PLAN EXAMINATION RFI HOLD

Maine Medical – East Tower 6 & 7th Floor Addition with Helipad

22 Bramhall St – Portland, Maine

Plans Date: 3/9/18

2 CURTAINWALL - SCUPPER
1 1/2" = 1'-0"

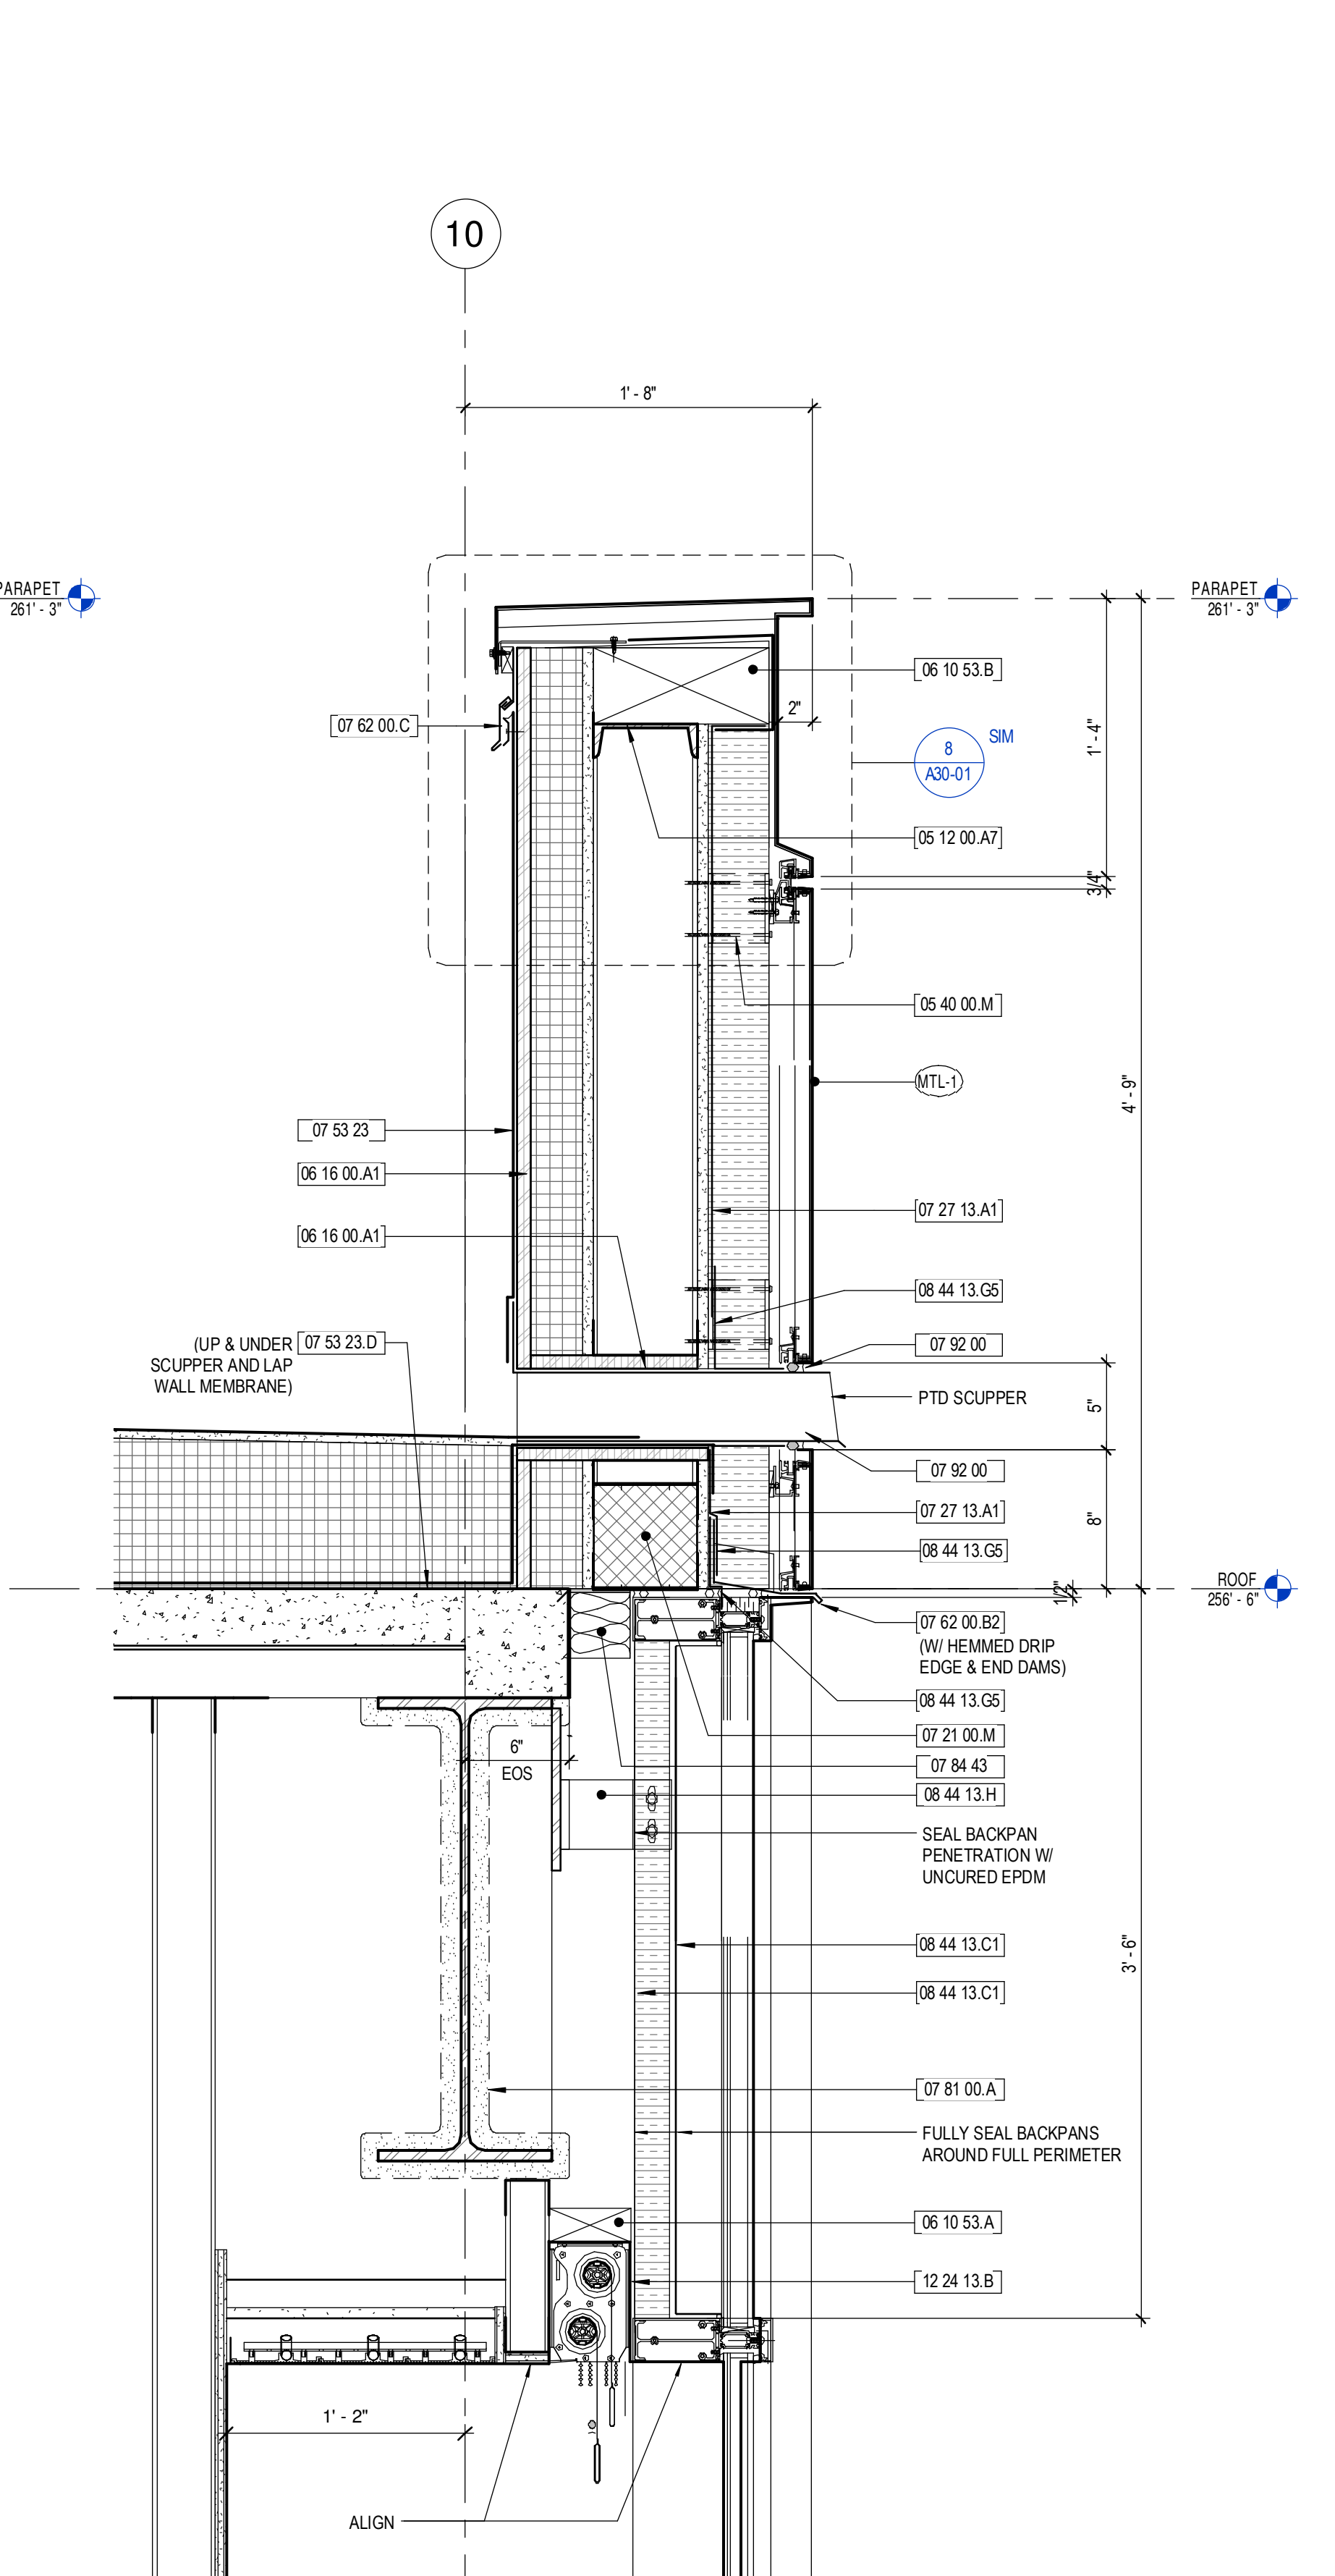
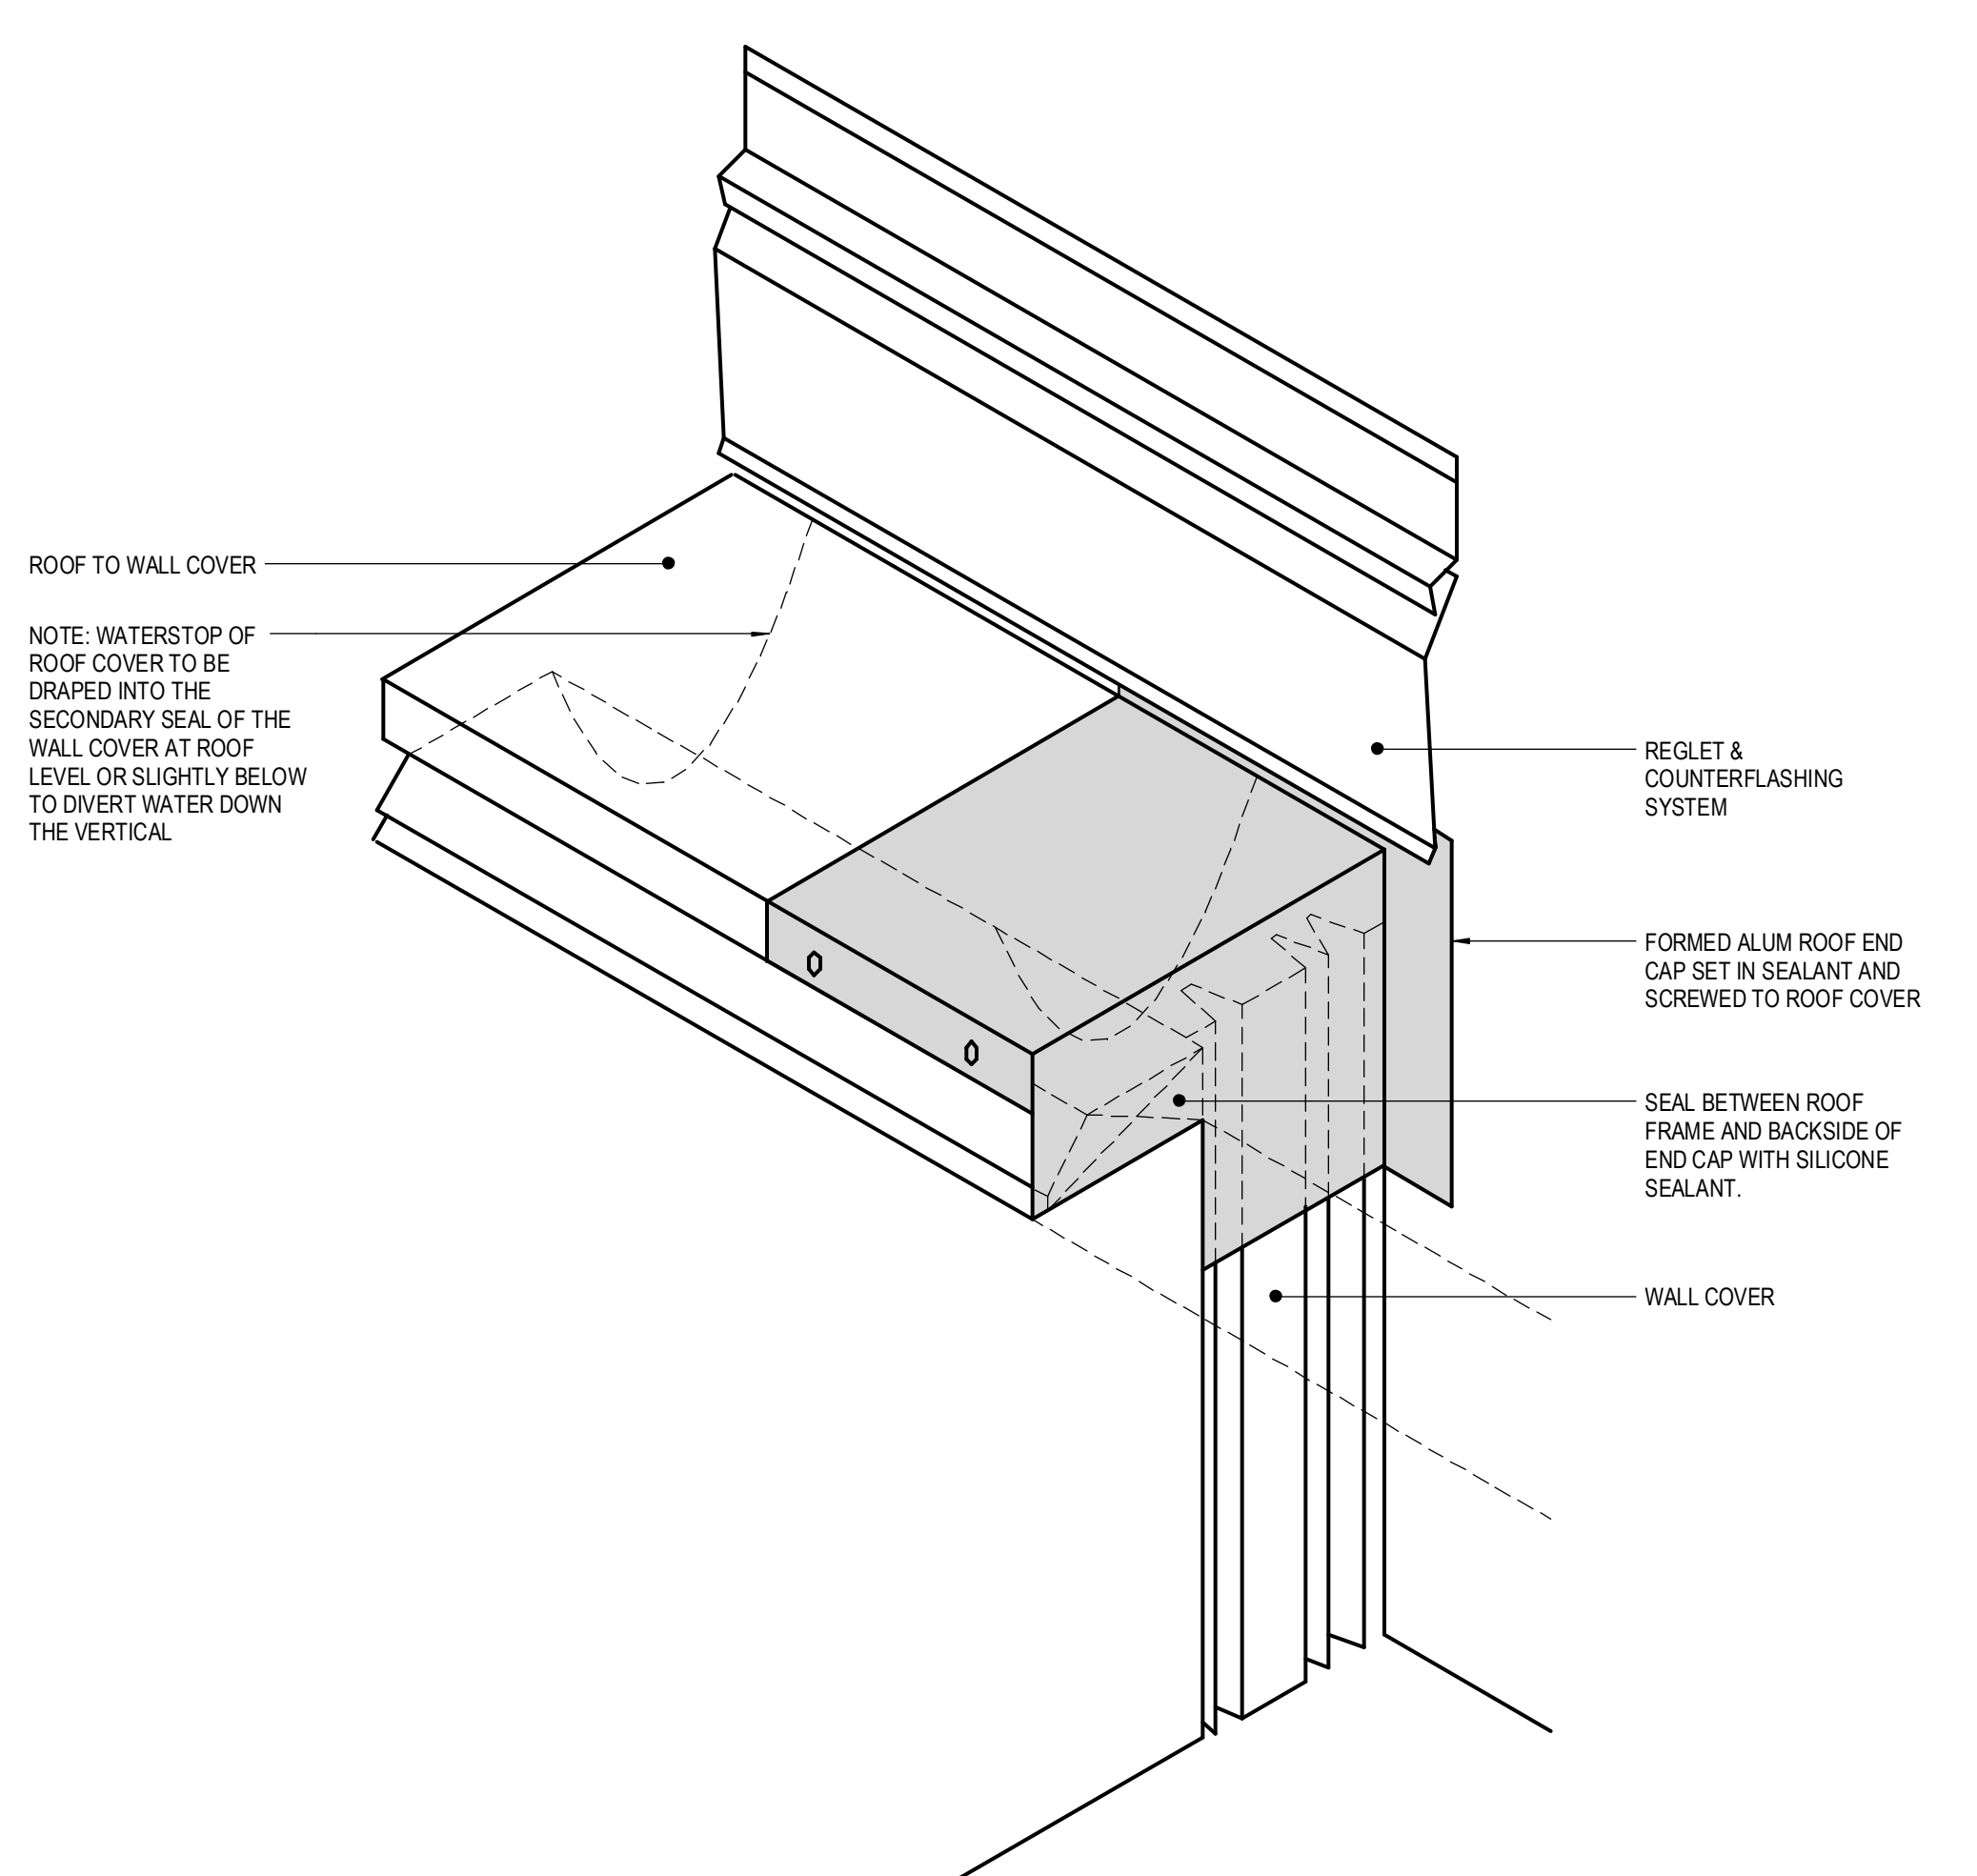
2. Provide the required fire-resistance ratings for the primary structural frame. A project code summary / analysis is not provided and the various details that show protected primary steel members (exterior section details on sheet A32-01 for example) note the protective material but do not provide a thickness or hour rating.
